Ribble Valley Planning Department  
Council Offices  
Ribble Valley Council  
Church Walk  
Clitheroe  
BB7 2RA

Dear Sirs Re: Muller's planning application for Pendle Mill Clitheroe.

Drawing file: planx_downloads / 24_0327_Proposed_Site_Plan_Rev_L.pdf

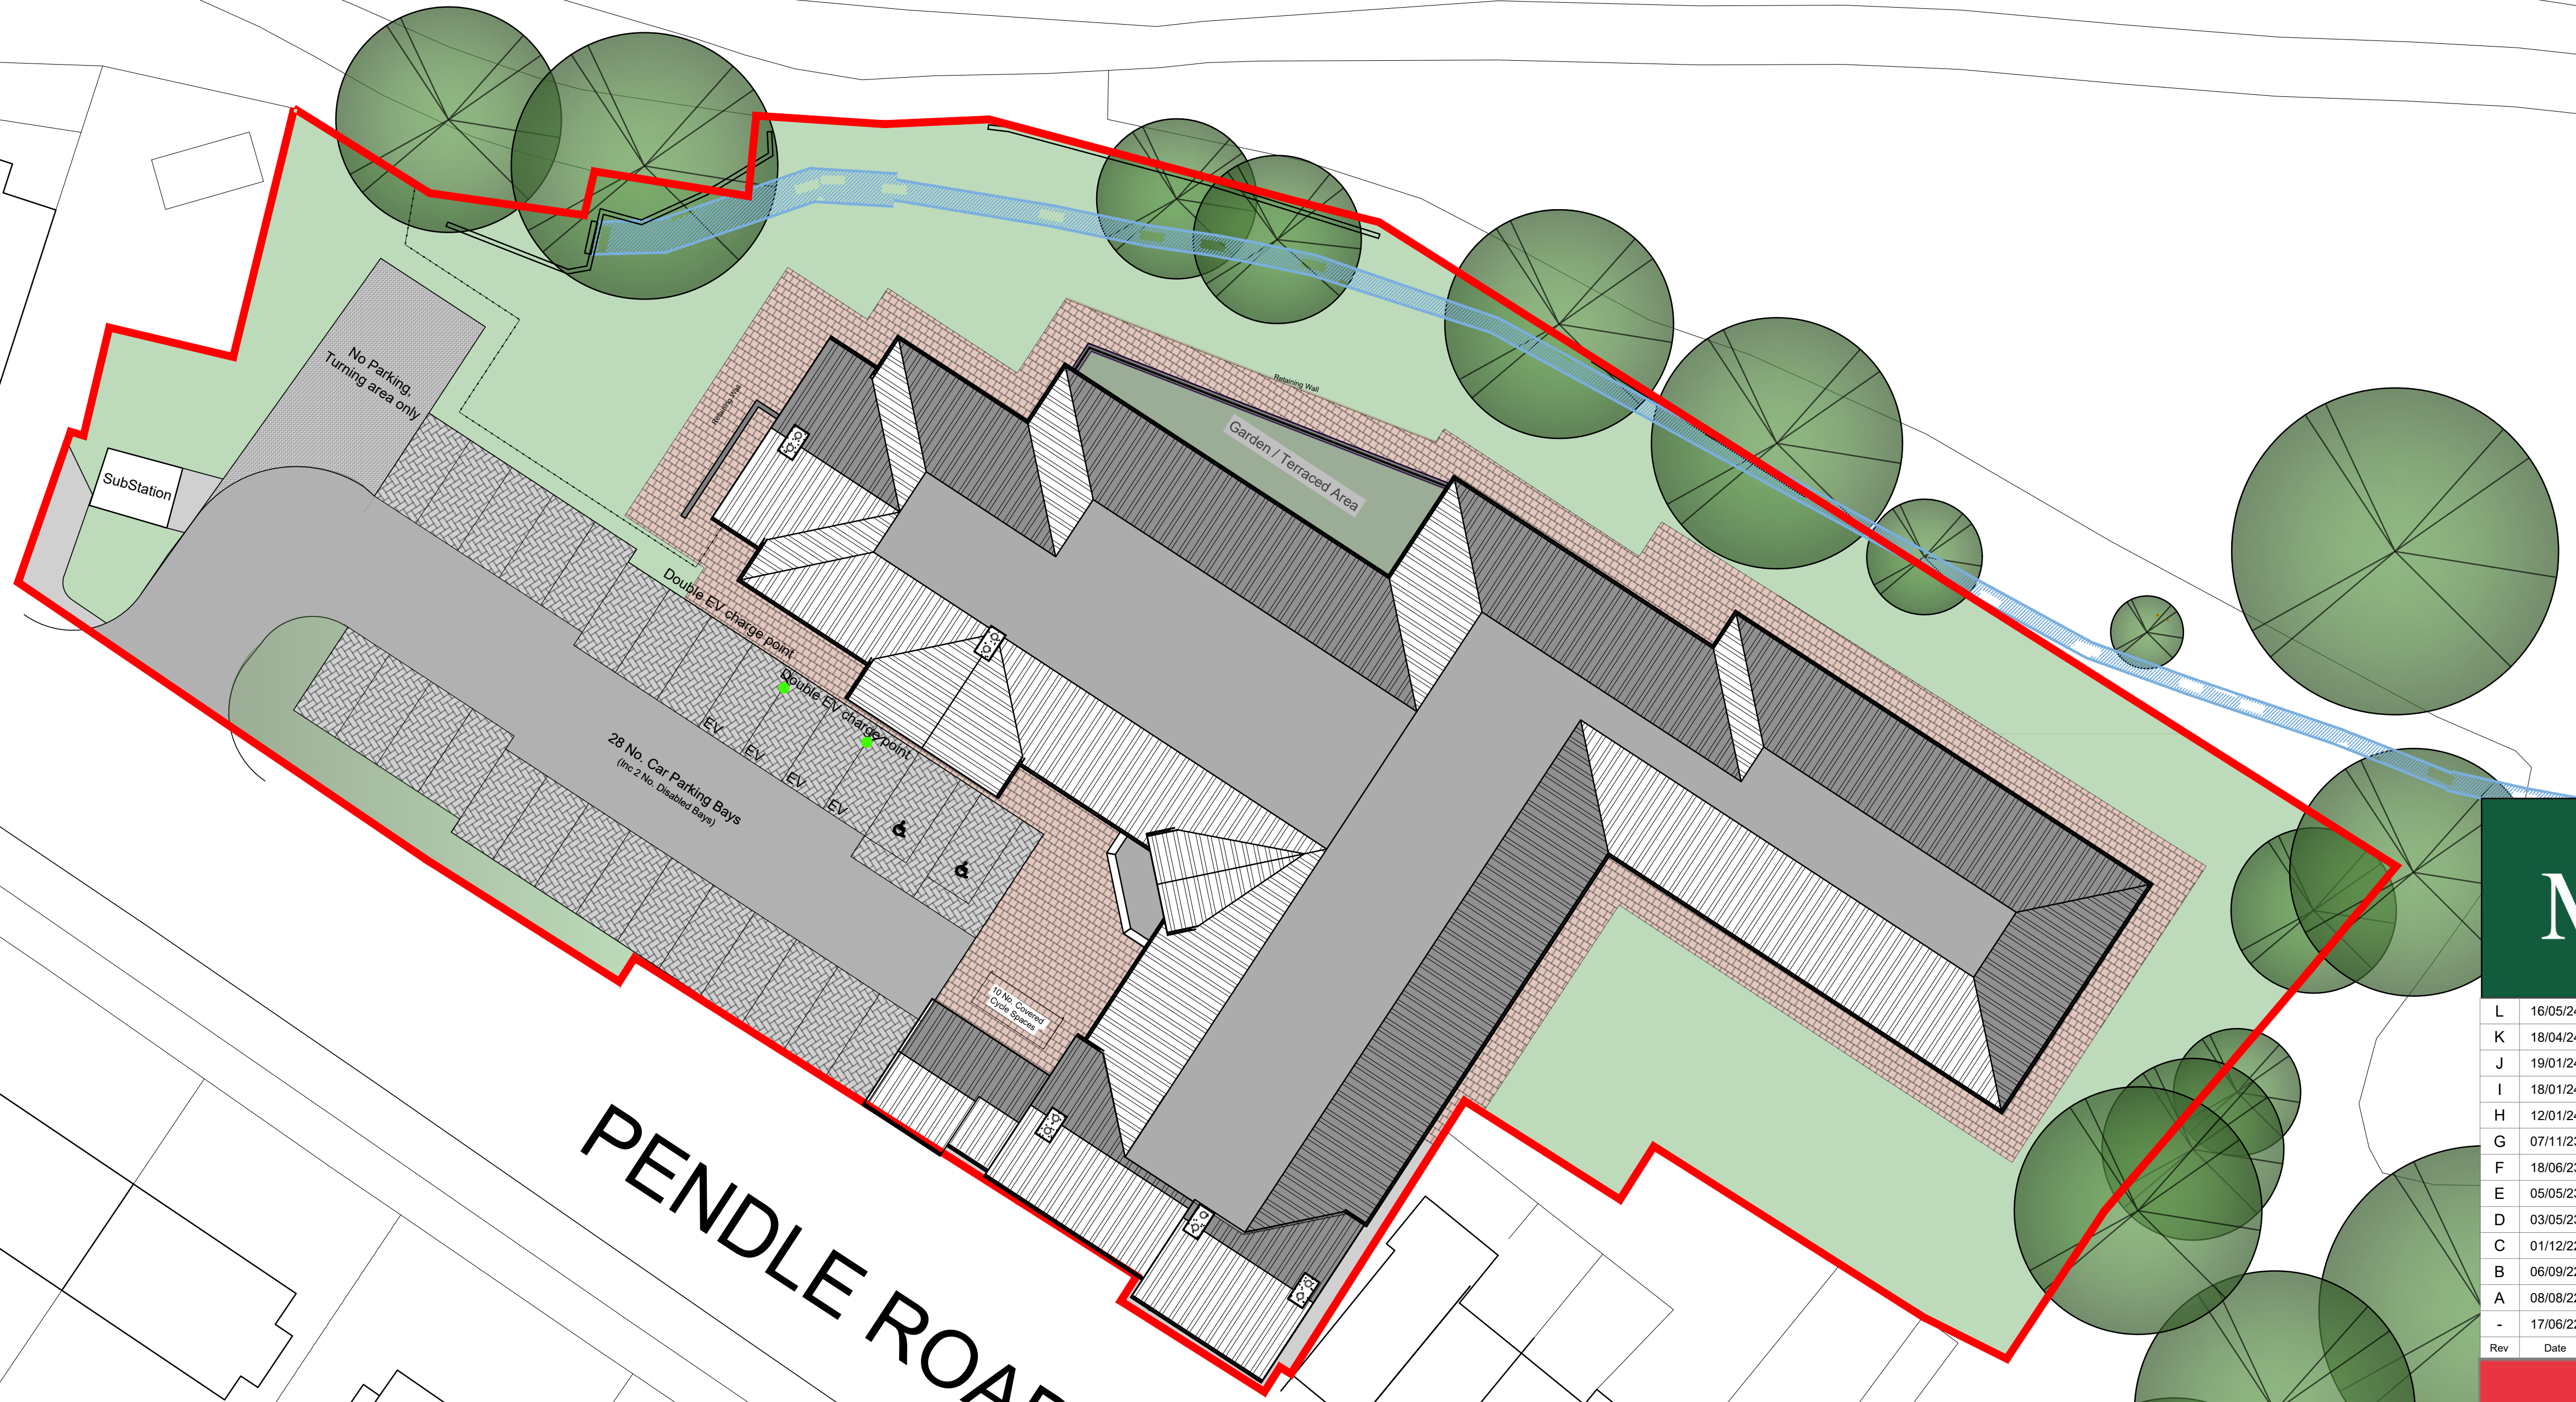
On the latest planning application, they have extended their plans on to land they do not own, as this was sold off and was classed as green land

- 1 The Street drainage is piped down this lane
- 2 The top water from the houses goes down this land
- 3 The surface water goes down this land

As the new plans block off this land what happened to the water it is on a very steep slope, and takes a lot of water if it cannot go down the lane, I get flooded

As you can see from the drawing, I have enclosed [REDACTED]  
the rear, If this lane is closed off as the plan shows I may get flooded.
